**REQUEST**

Current Zoning: UMUD-O (uptown mixed use development, optional)  
Proposed Zoning: UMUD-O SPA (uptown mixed use development, optional, site plan amendment)

The petition proposes a site plan amendment to approved rezoning petition, 2021-163. This rezoning would amend the existing conditional plan to add an additional vehicular access point and pedestrian connectivity.

SHEET NUMBER  
**RZ-01**

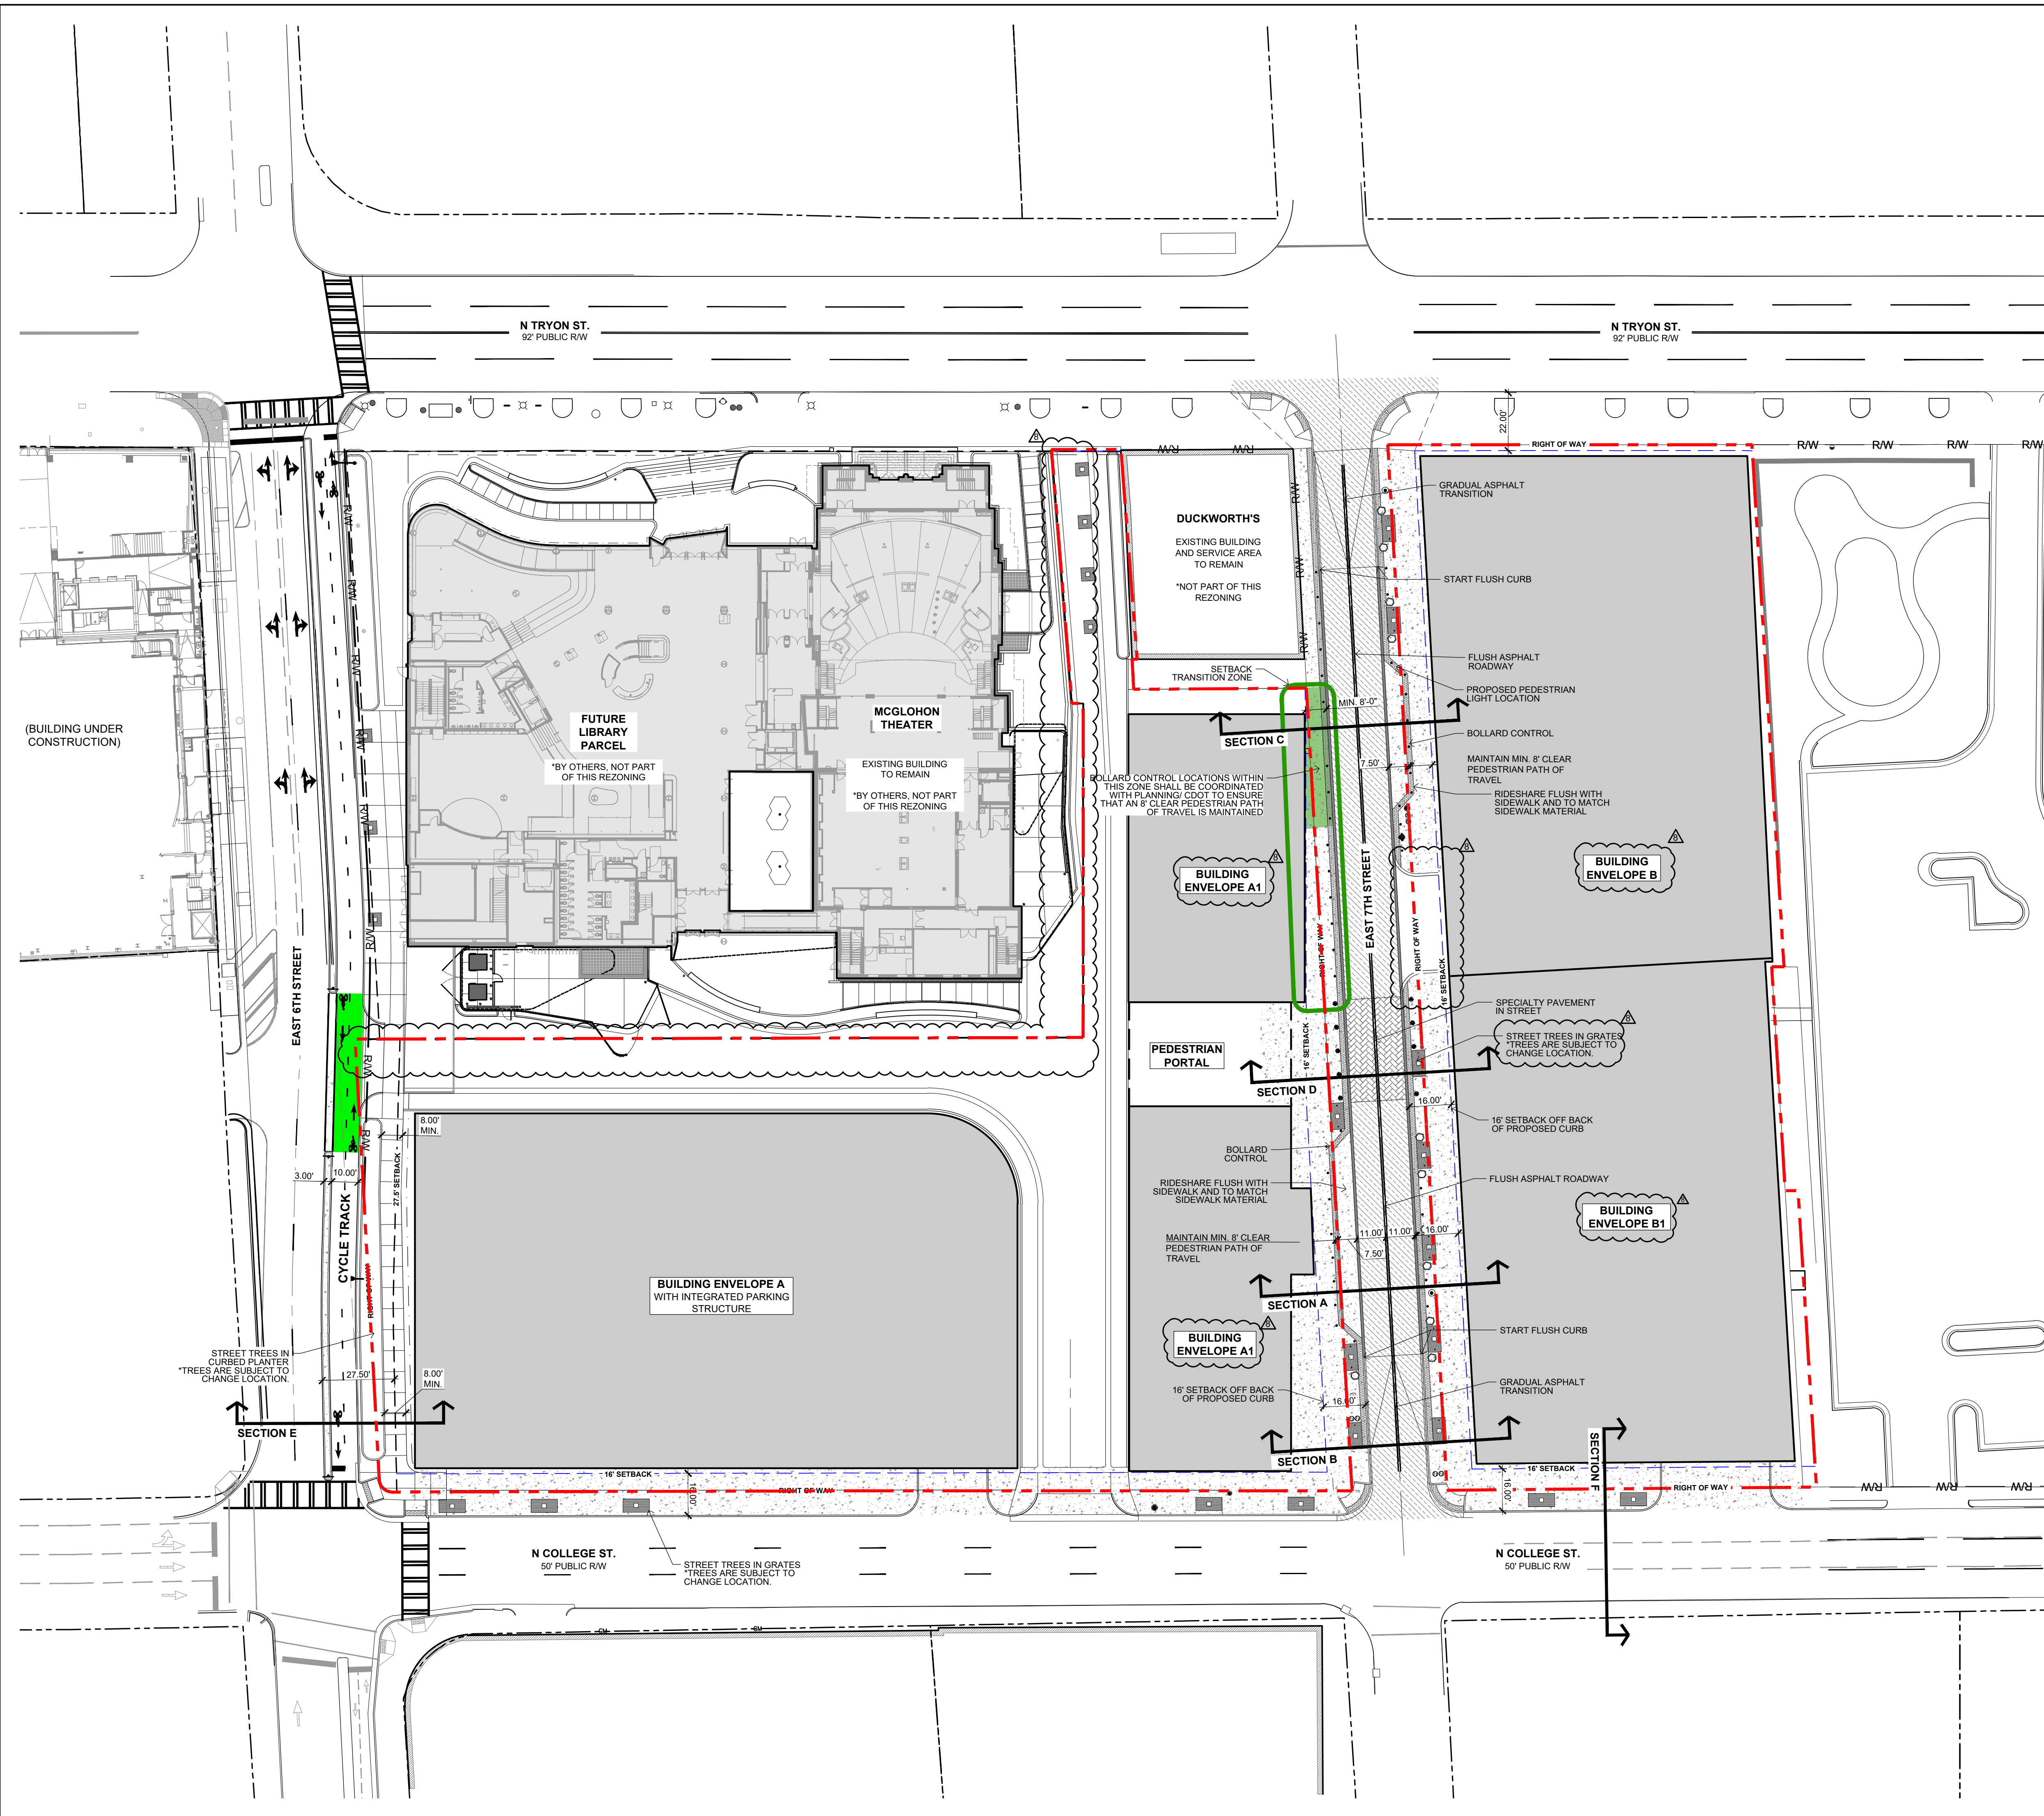
1. Revise conditional notes and site plan to either dedicate right-of-way or provide a sidewalk utility easement (SUE). The SUE should be placed 2 feet behind the back of walkway, or at the face of the building where 2 feet cannot be obtained.
2. Add a conditional note specifying, "the Petitioner shall dedicate and convey in fee simple all rights-of-way to the City before the site's first building certificate of occupancy is issued. CDOT requests rights-of-way set at 2' behind back of sidewalk where feasible."
